Subject: Y/22/19/PL – Demolition of existing redundant garage building & erection of 1 No. dwelling and associated works (alternative following Y/68/17/PL)

Having now had chance to review the submitted report entitled 'Combined Geotechnical and Ground Contamination Risk Assessment and Remediation Strategy' [Report Ref: R18-13073 Dated 10/07/2018] I will state the following:

- Figure 1 Site Location Plan
- Figure 2 Site Walkover Plan
- Figure 3 Remedial Works Plan

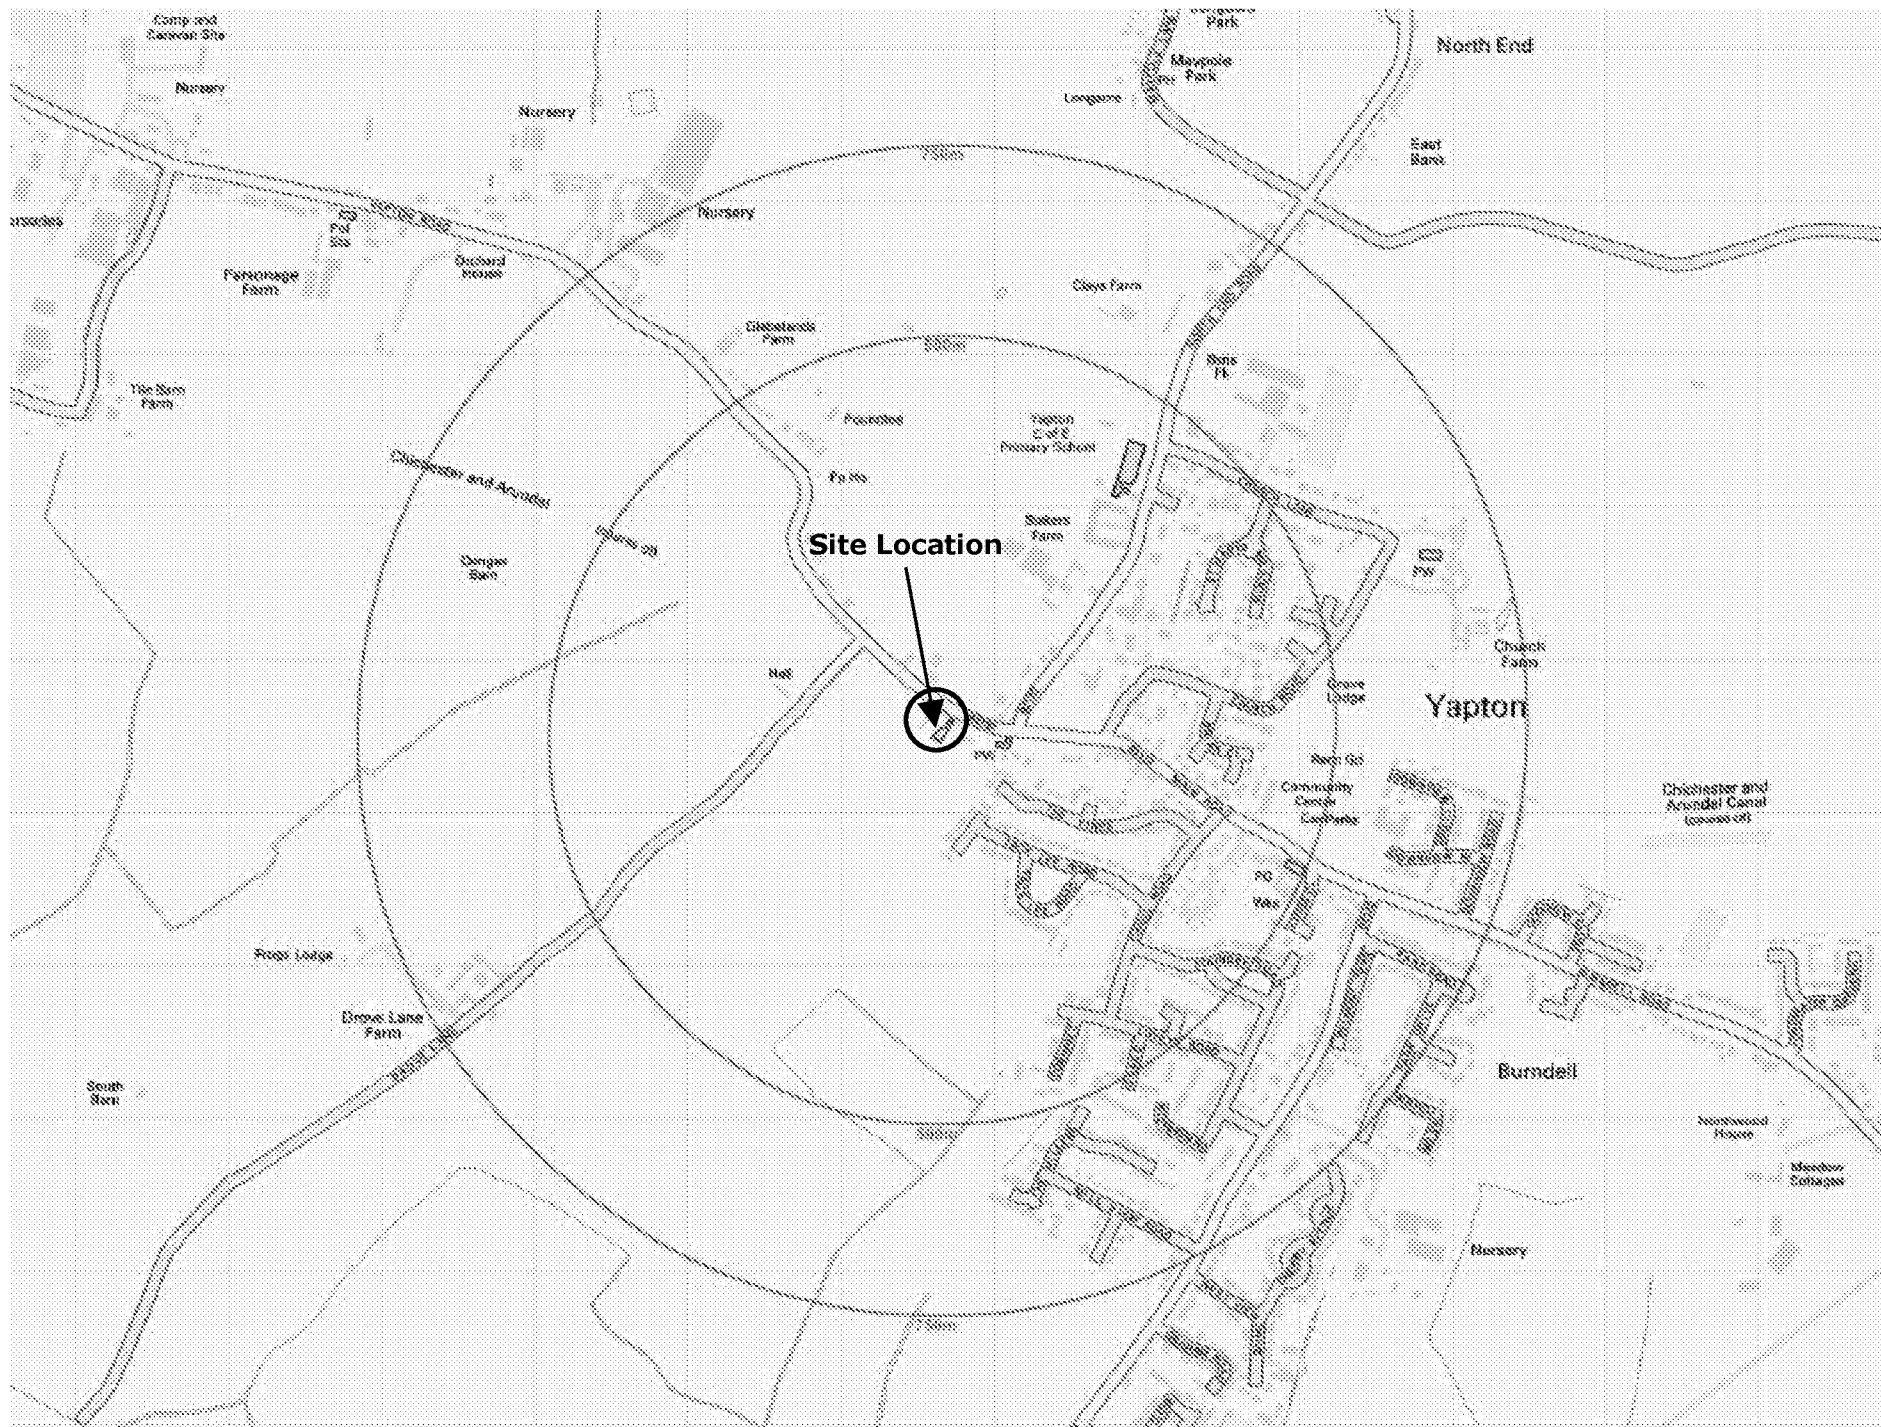
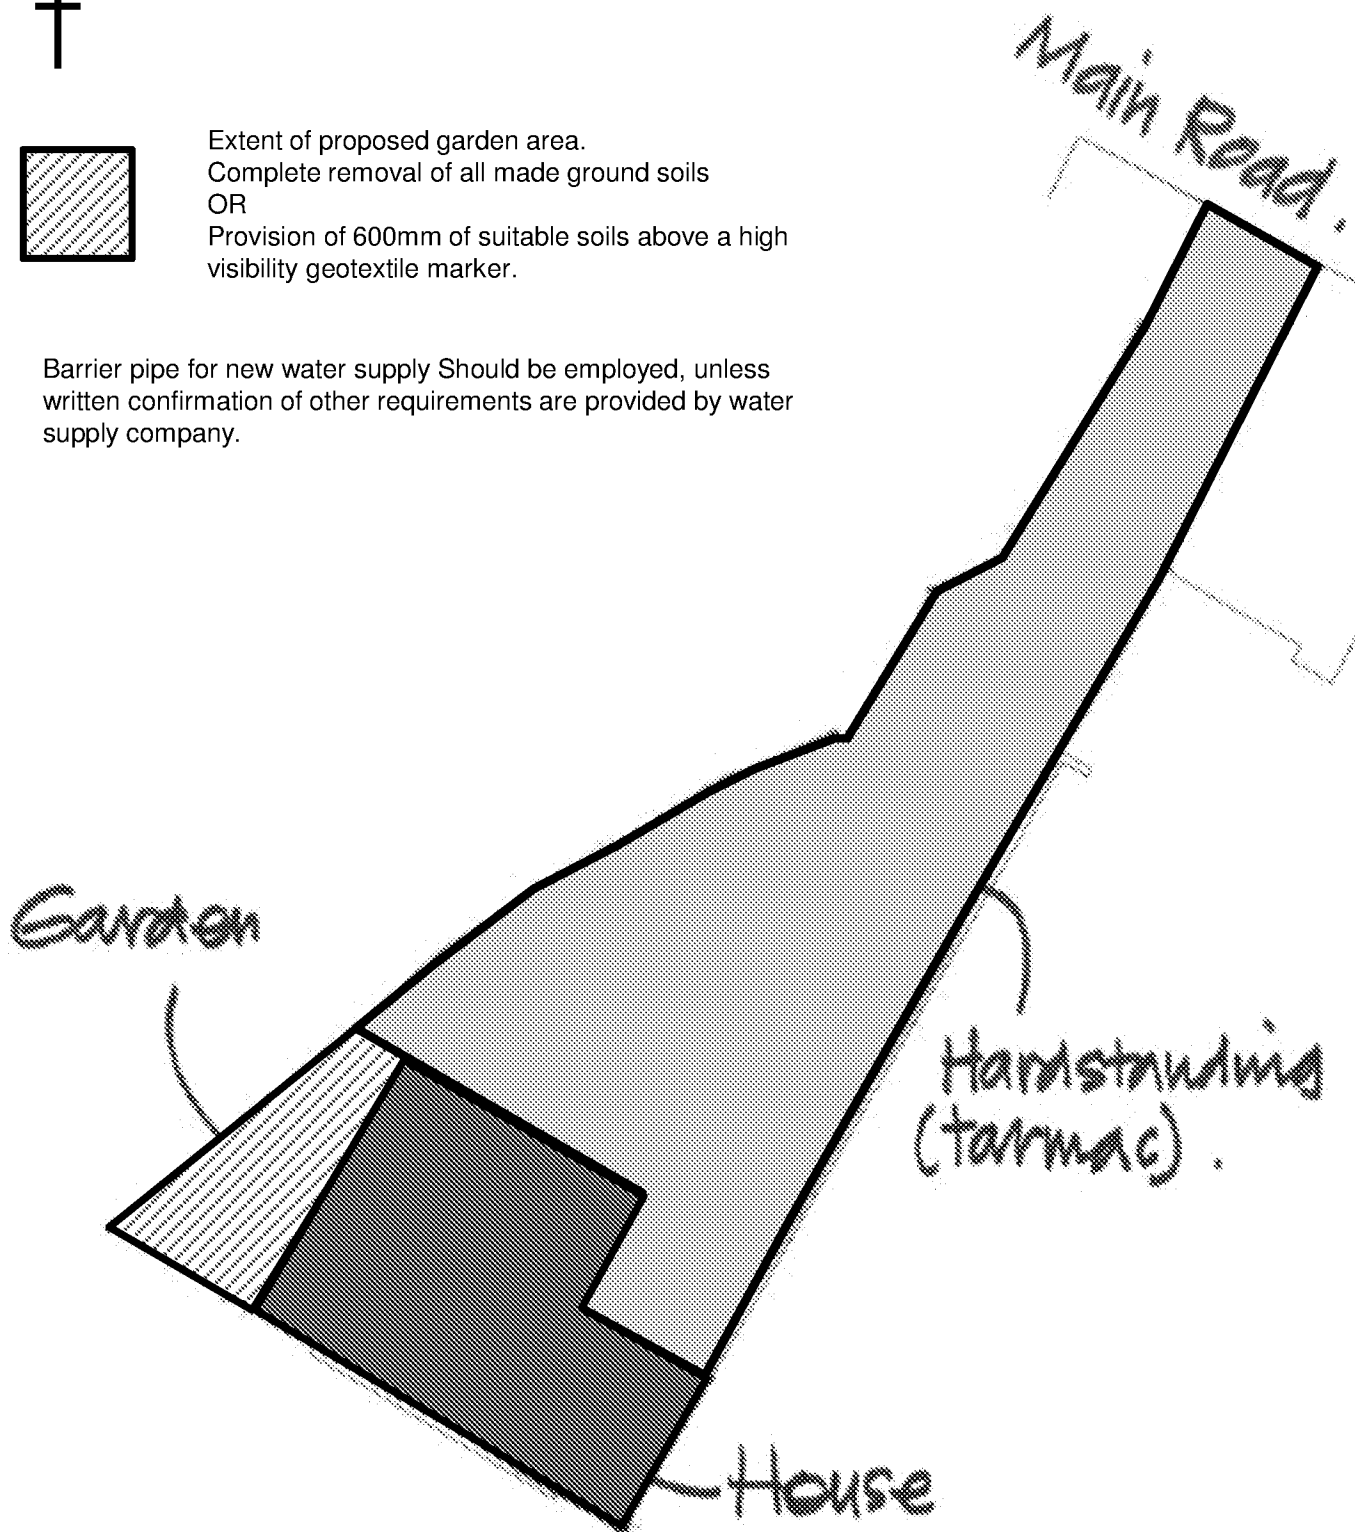
If one or other of the two options as stated within section 12.1 'Options Appraisal' as set out under the proposed section 12. 'Remediation Strategy' of the report are followed by the construction contractors to give the reported outcome as set-out in section 14 as shown below; as well as retaining the site orientation as shown in Figure 3 herein with no deviation without prior written consent from the Planning Authority, then the Environmental Health department is satisfied that the contamination will be removed / encased with hardstanding thereby removing the pollutant linkages for this site...
